Your ref: SSD-11606719
File no: MC-20-00011

SSD-11606719 – Eastern Creek Recycling Ecology Park Throughput Increase

Blacktown Council's submission to SSD-11606719 – Eastern Creek Recycling Ecology Park Throughput Increase

19-692-C315

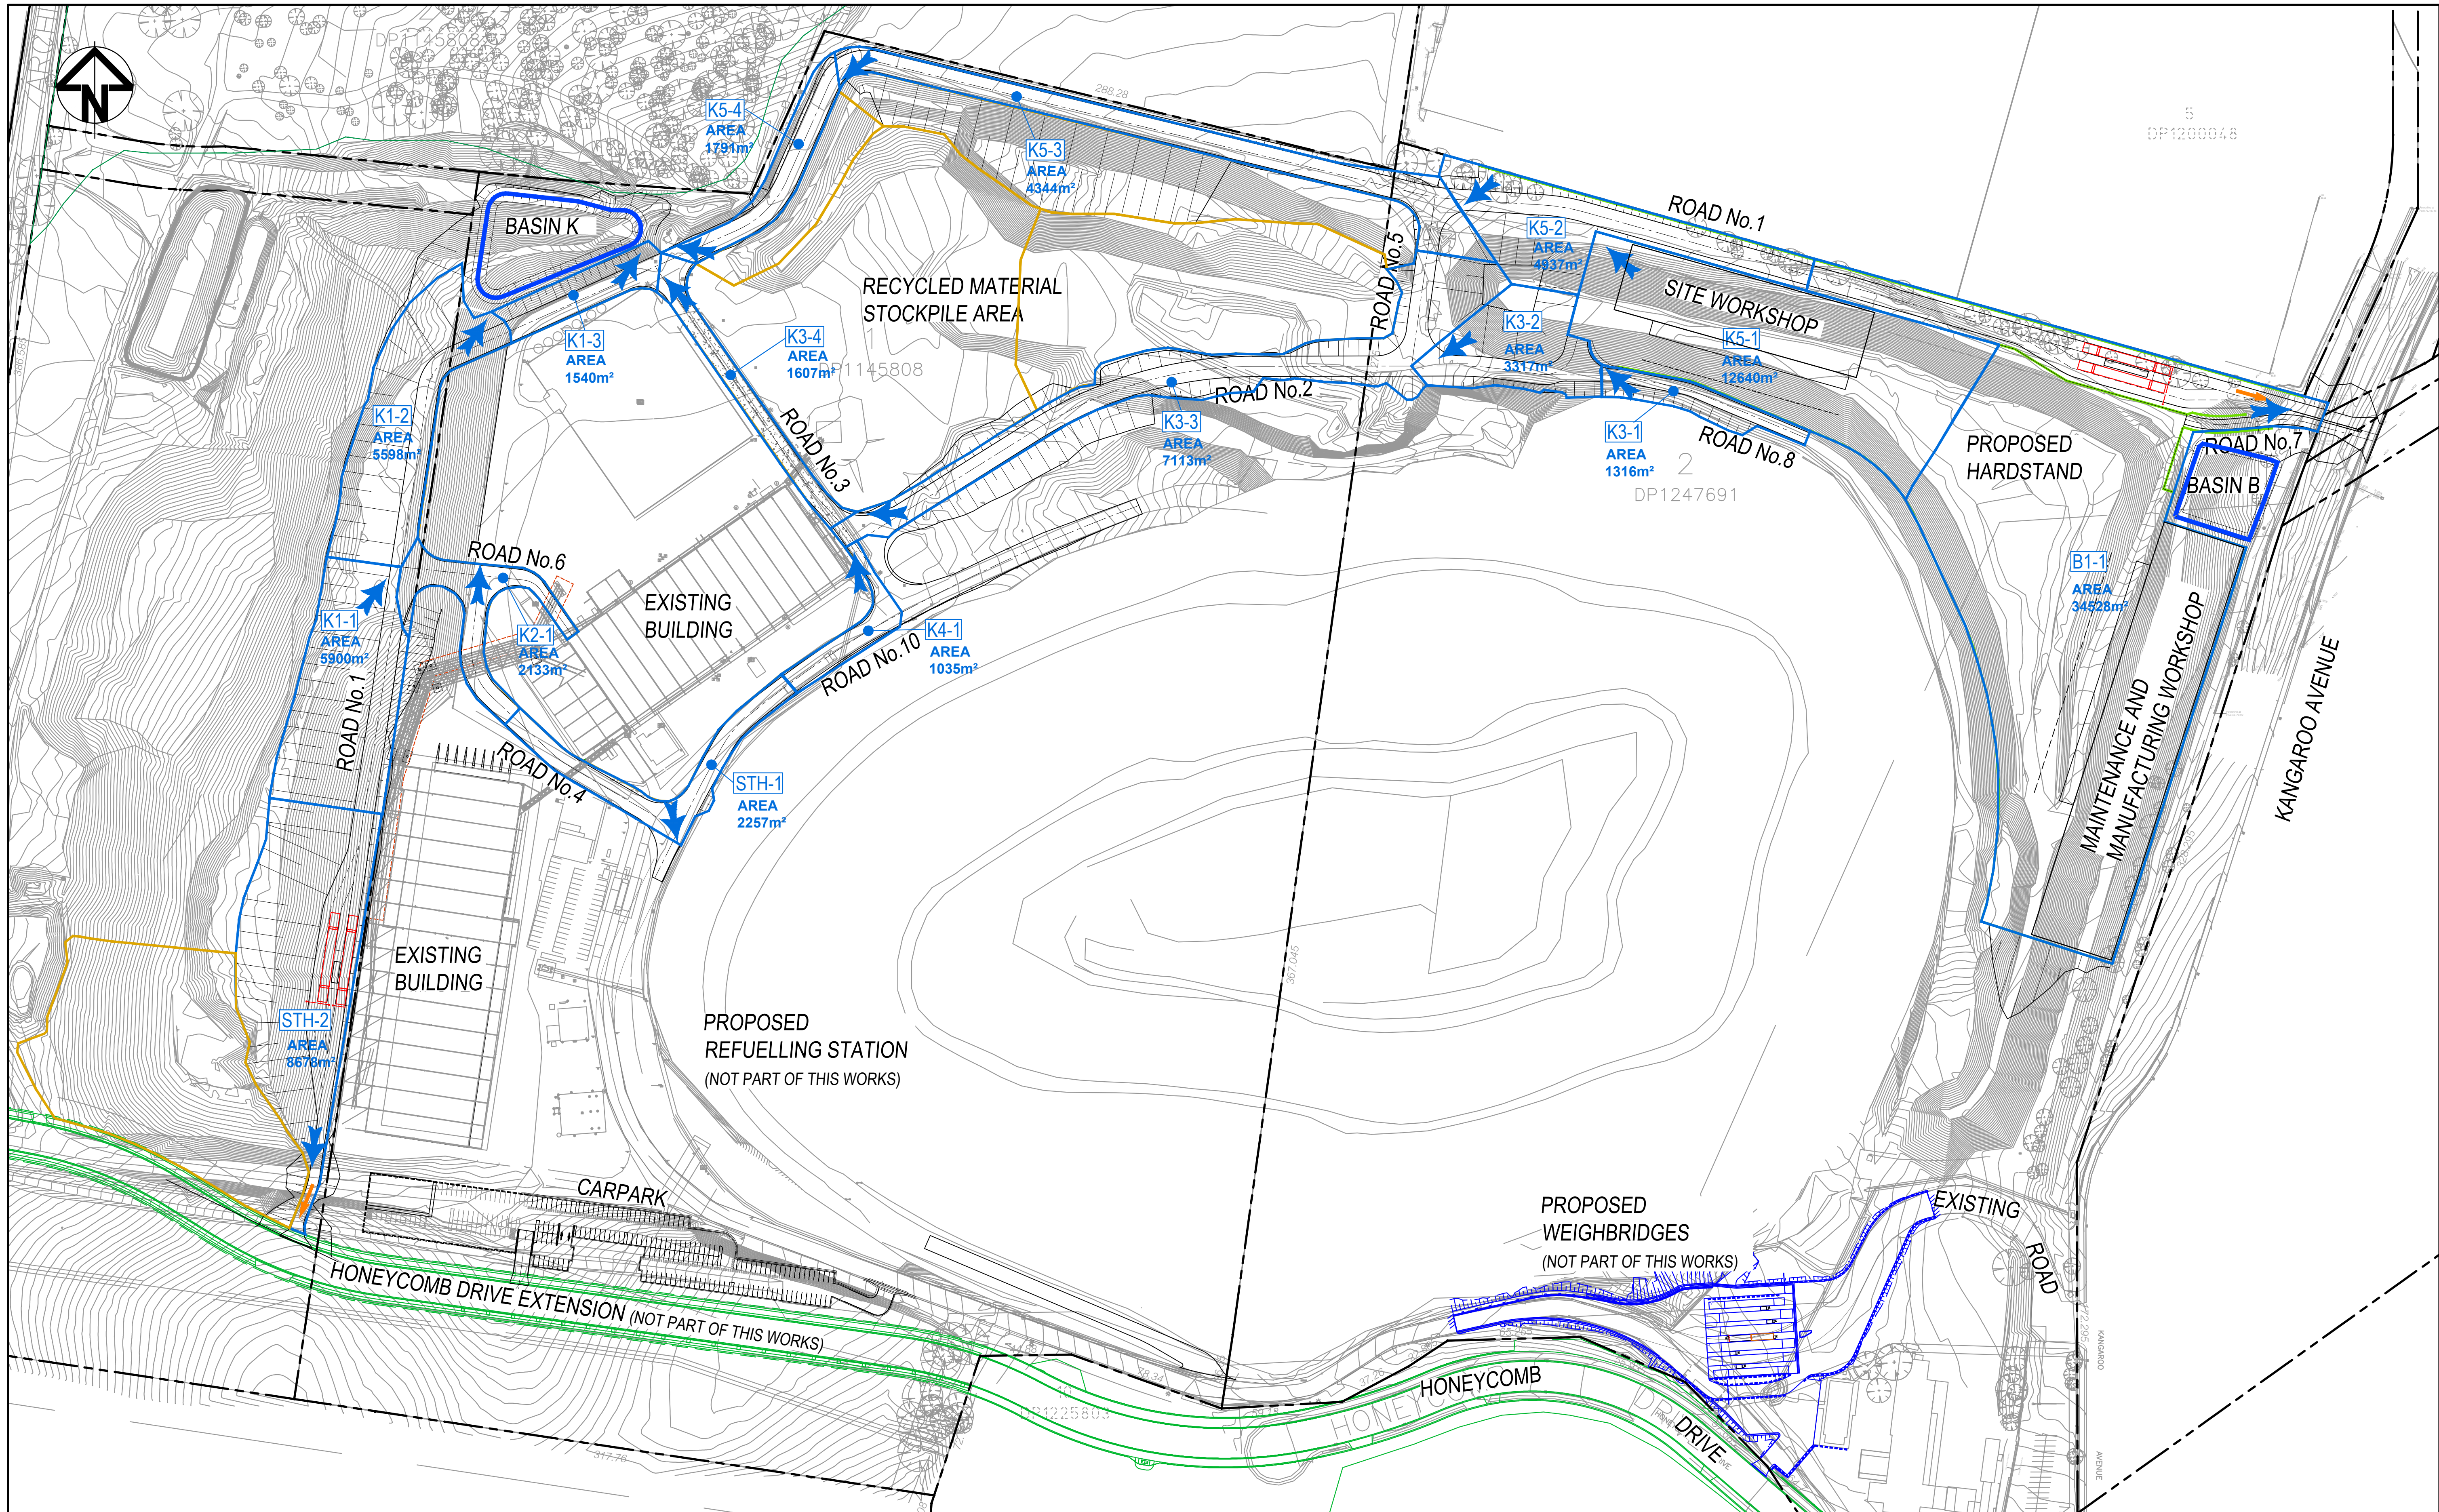
- b. There is insufficient information shown on drawing C315(I) to understand how Basin B will operate. It is understood to be a combined bioretention and detention basin. On a dedicated separate plan provide detailed plans and sections through Basin B. Provide details of the control pits and weirs and pipe(s) out. Provide a sealed subsoil collection pit and discharge the subsoil flows downstream of the control pits. Bioretention generally to comply with the details outlined in Council's Water Sensitive Urban Design standard drawings with a saturated zone. Provide a vehicular maintenance access ramp down to the base of the basin with a track down one side of the bio.

Project	EASTERN CREEK RECYCLING ECOLOGY PARK THROUGHPUT INCREASE
Title	NORTHERN AND EASTERN BERM BULK EARTHWORKS PLAN

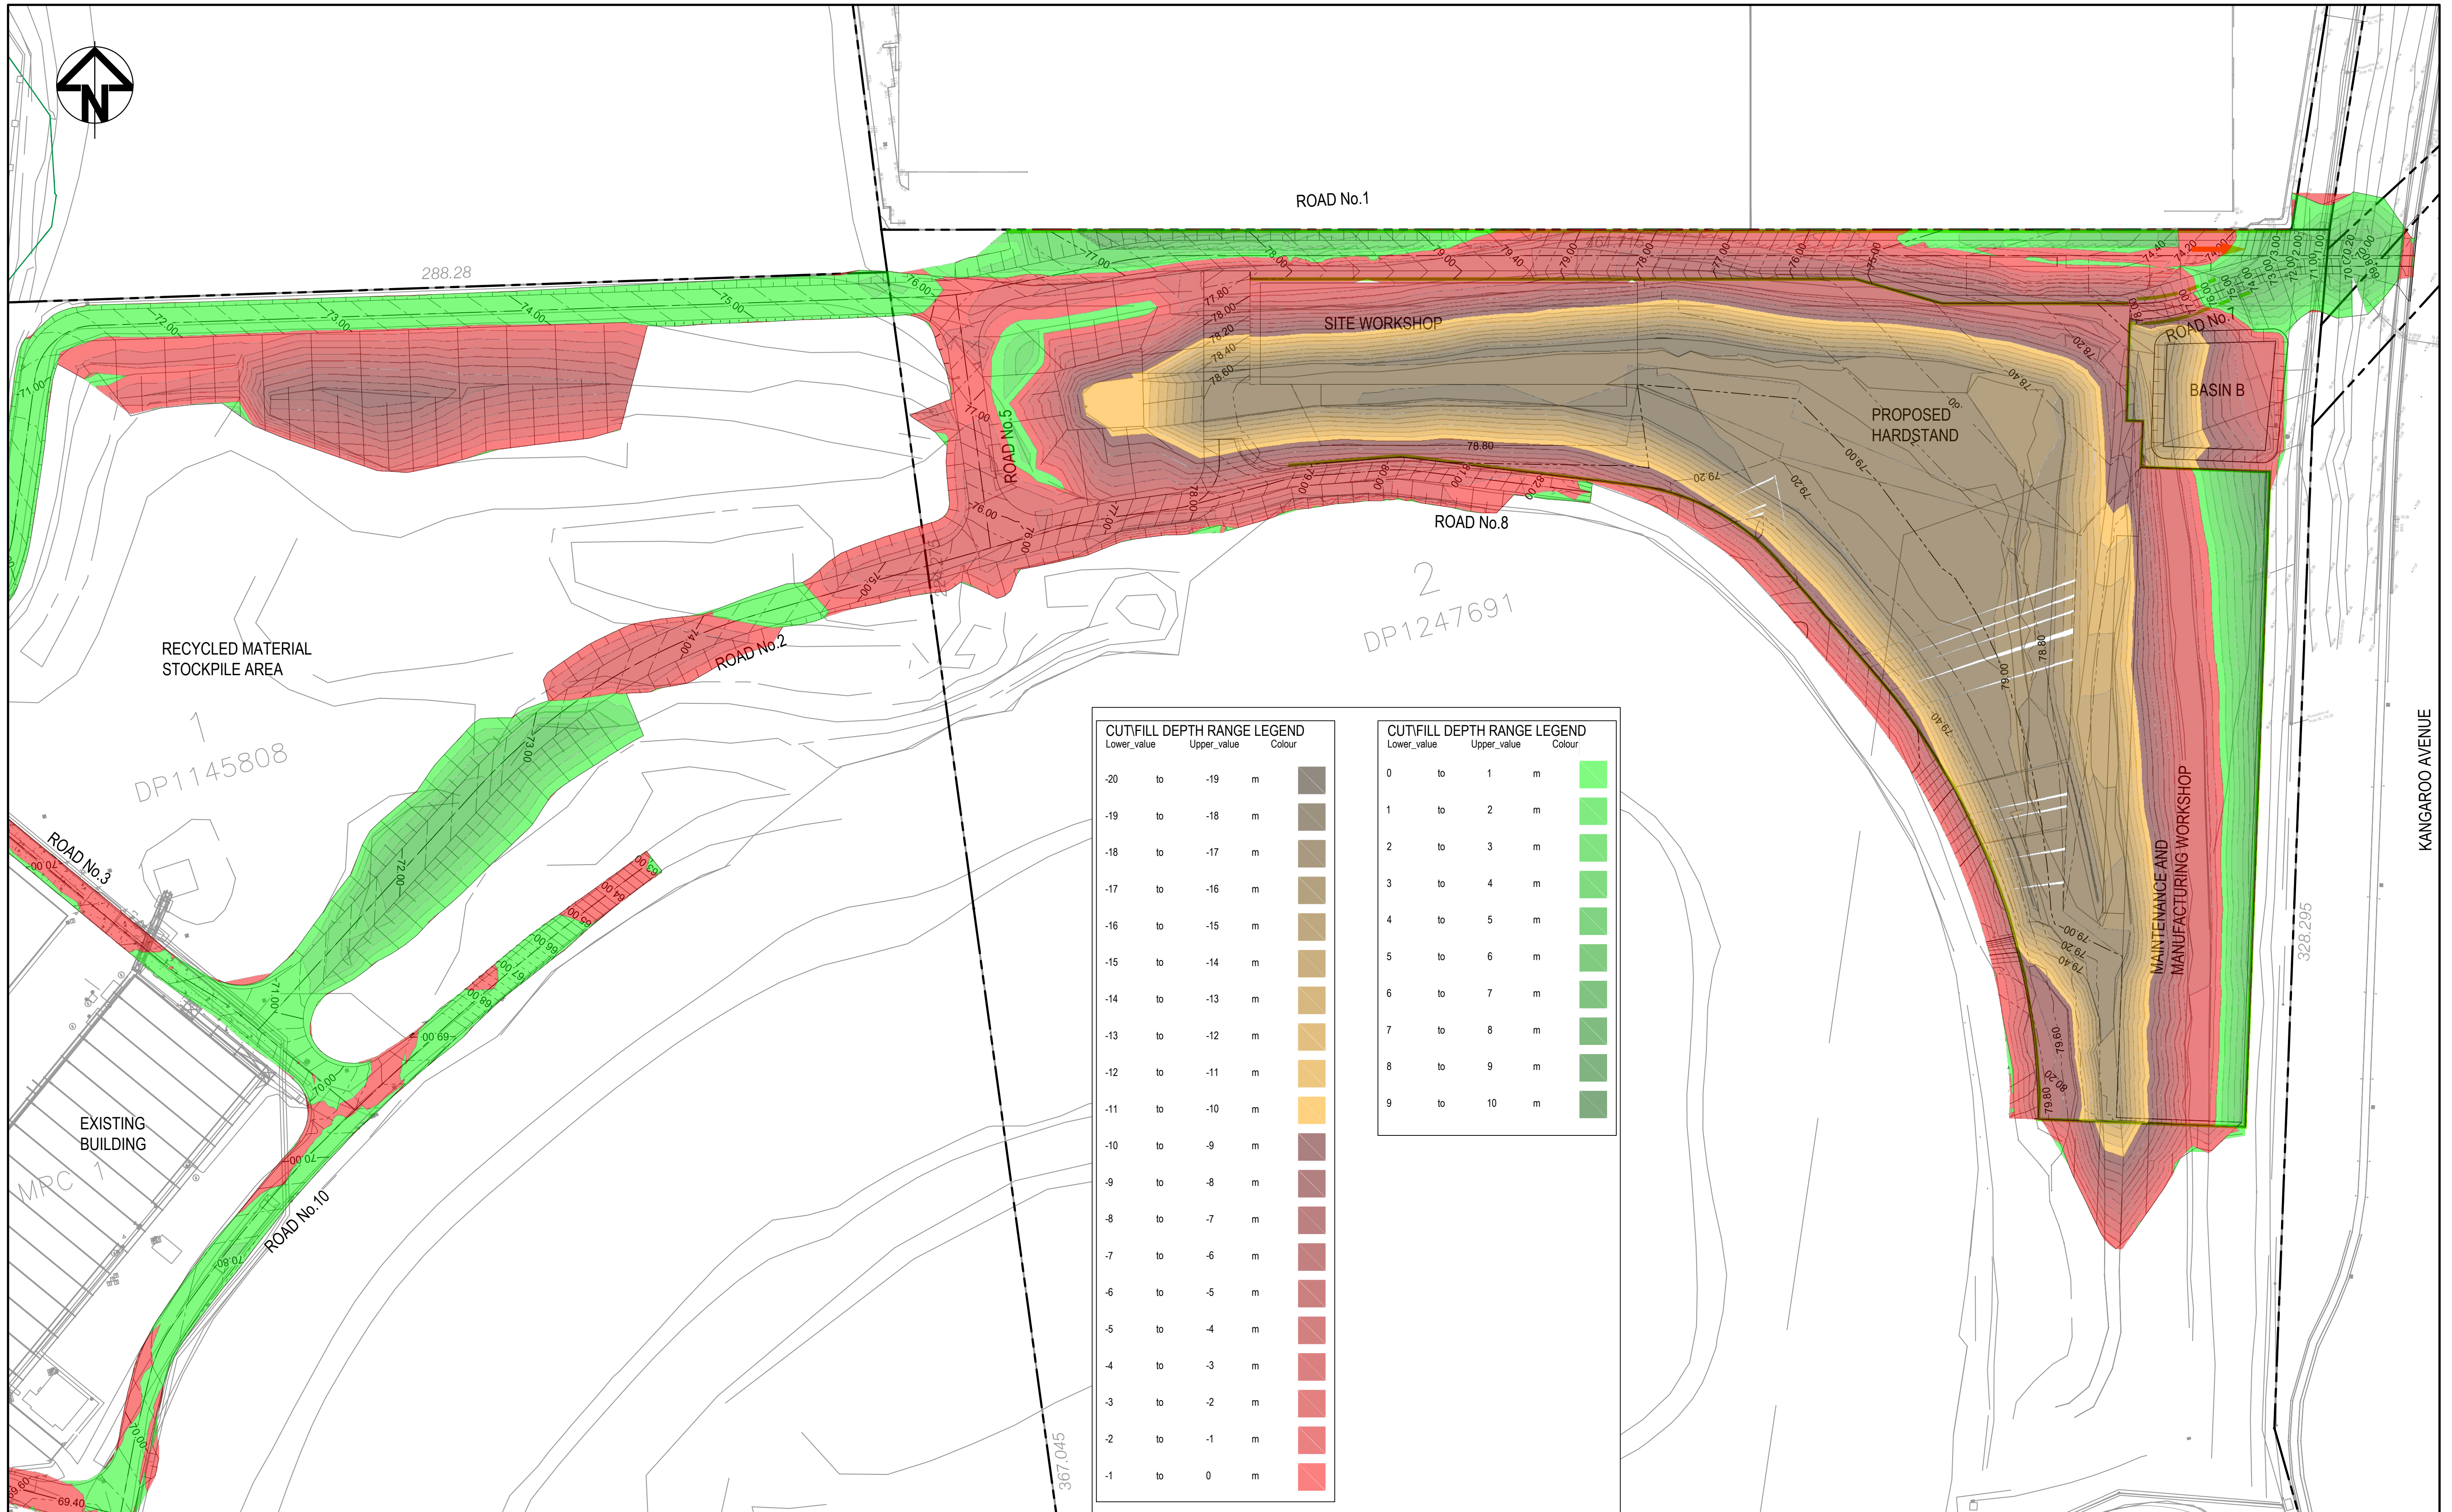
- d. On drawing C320(B) and C321(A) provide more variations in colours for fill and cut. The current gradations are too similar to assess.
 - e. Provide details/sections of the retaining walls.
